TfNSW Reference: SYD20/00698/02 (A35156615)  
DPIE Reference: SSD-10472

**PROPOSED EXPANSION OF THE MUSEUMS DISCOVERY CENTRE - 2 GREEN ROAD, CASTLE HILL**

TfNSW has reviewed the submitted application and requests the following additional information for further assessment:

Figure 9 Existing bus routes servicing the MDC site

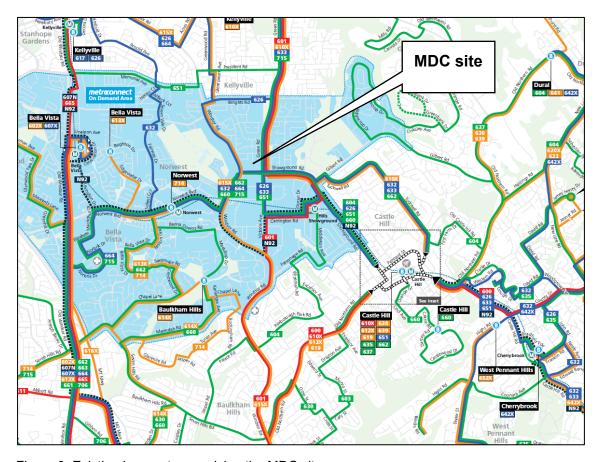
5. Section 2.6 – requires to provide assessment on bus services available on Windsor Road, Showground Road and Green Road. The report has only assessed bus services at Showground Metro station rather than those immediate to the site.

Figure 14 Proposed vehicle circulation

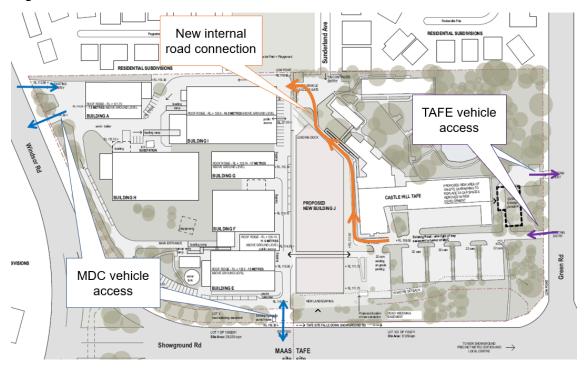
3. TfNSW has concerns with regard to the location of the access on Showground Road being located close to the traffic signals at Windsor Road and the merging of traffic into different lanes approaching the Showground Road/Green Road/Victoria Road intersection. TfNSW requests that the access on Showground Road should be used for heavy vehicle movement only and the general public should solely use the access on Windsor Road. The proponent is to provide appropriate arrangements to ensure this requirement is met.

4. Justification is required for vehicle connectivity between MDC and TAFE sites. TfNSW requests access to TAFE should be provided via Green Road only.

Figure 26 Construction vehicle routes

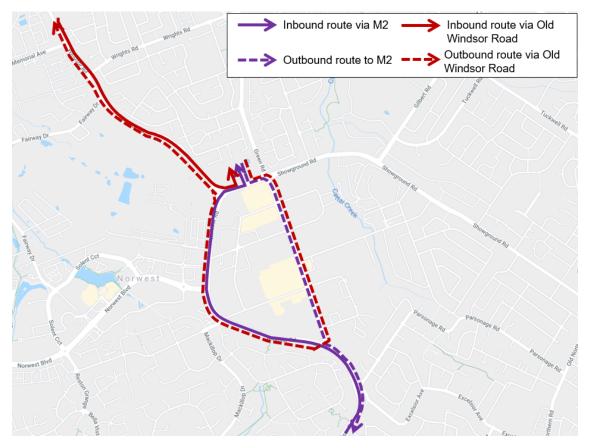
2. Additional swept path analysis should be provided for the longest construction vehicle accessing the site. The accesses should cater for the longest vehicle during both construction and operation of the site.

Appendix C: Swept Path Analysis

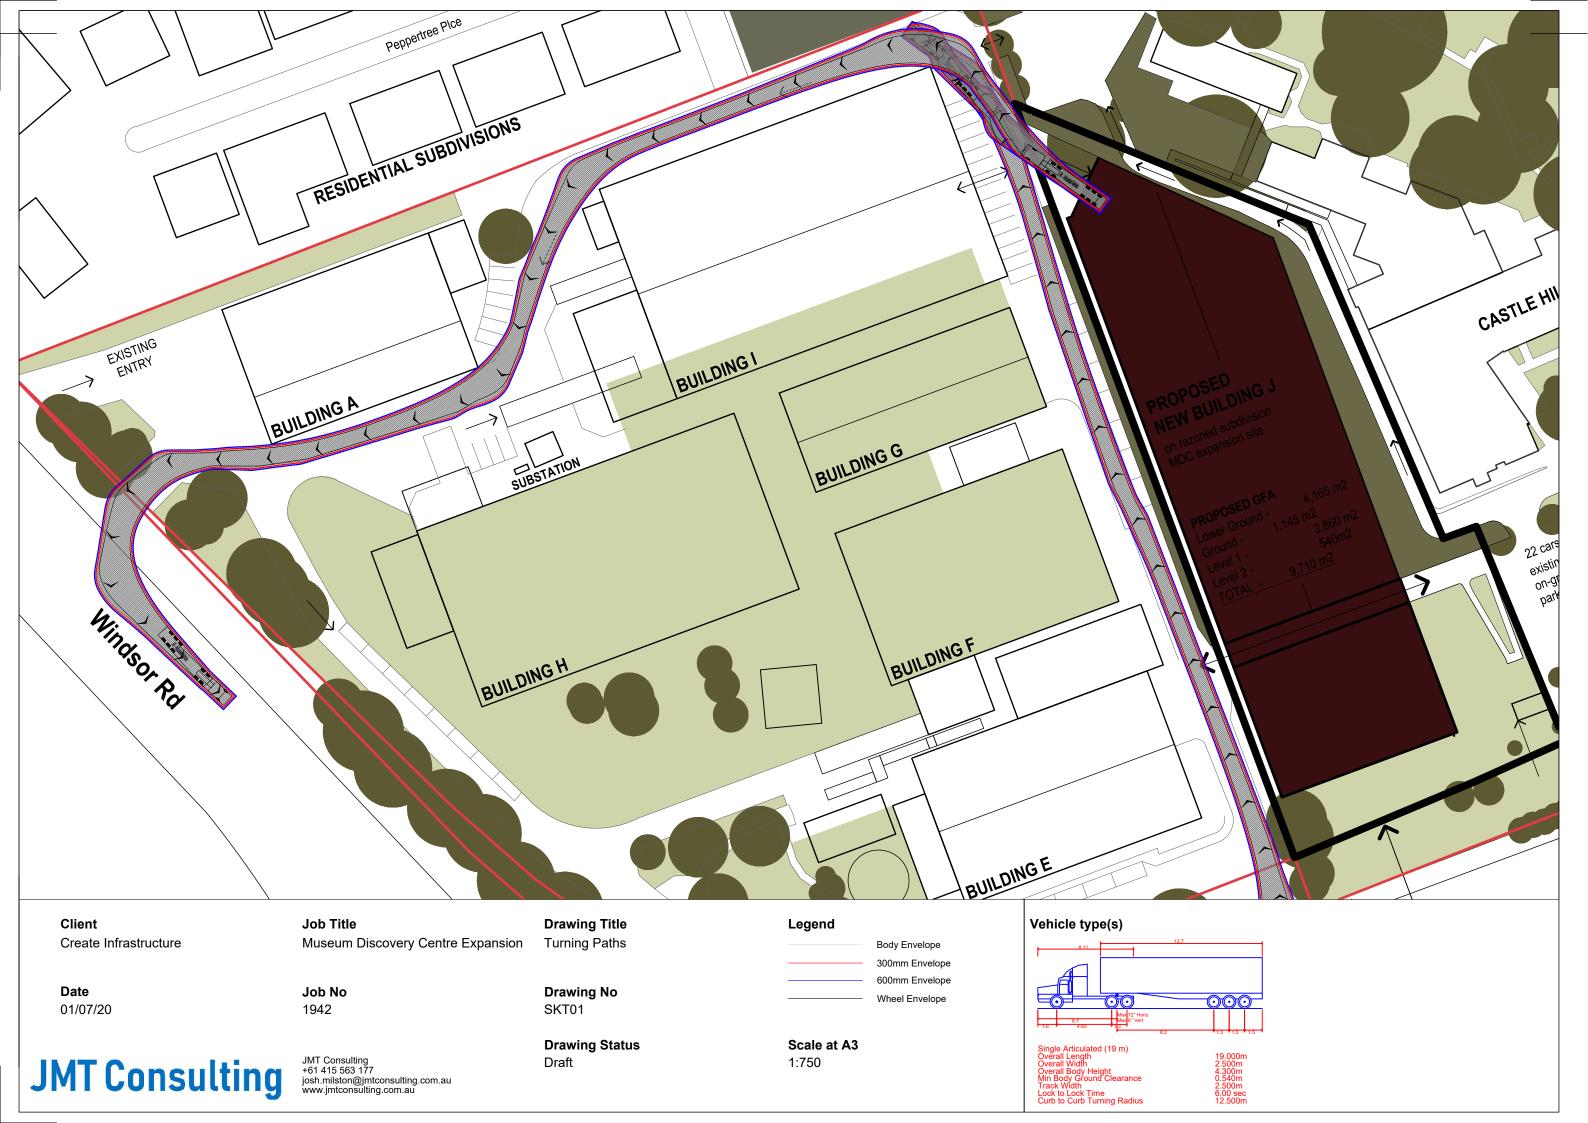
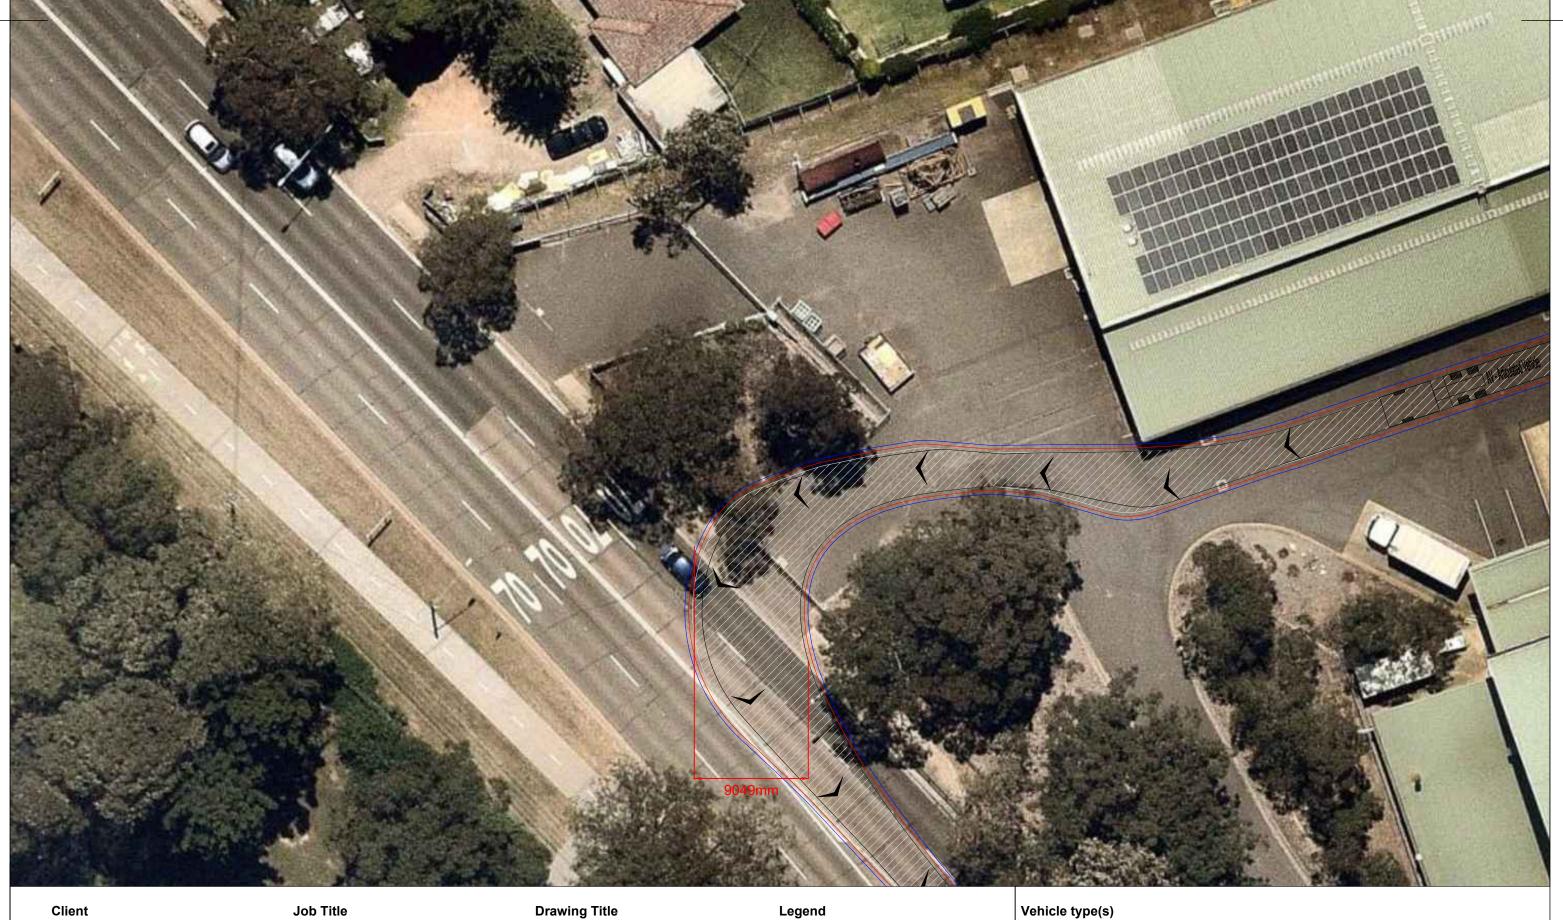
1. TfNSW requests scaled swept path analysis showing how the proposed 19m vehicles enter and exit the site from the kerb lanes on Windsor Road and Showground Road. The plans should show the dimensions of the driveways and lane arrangement on both Windsor Road and Showground Road. Please note the submitted swept path diagram does not show this information.
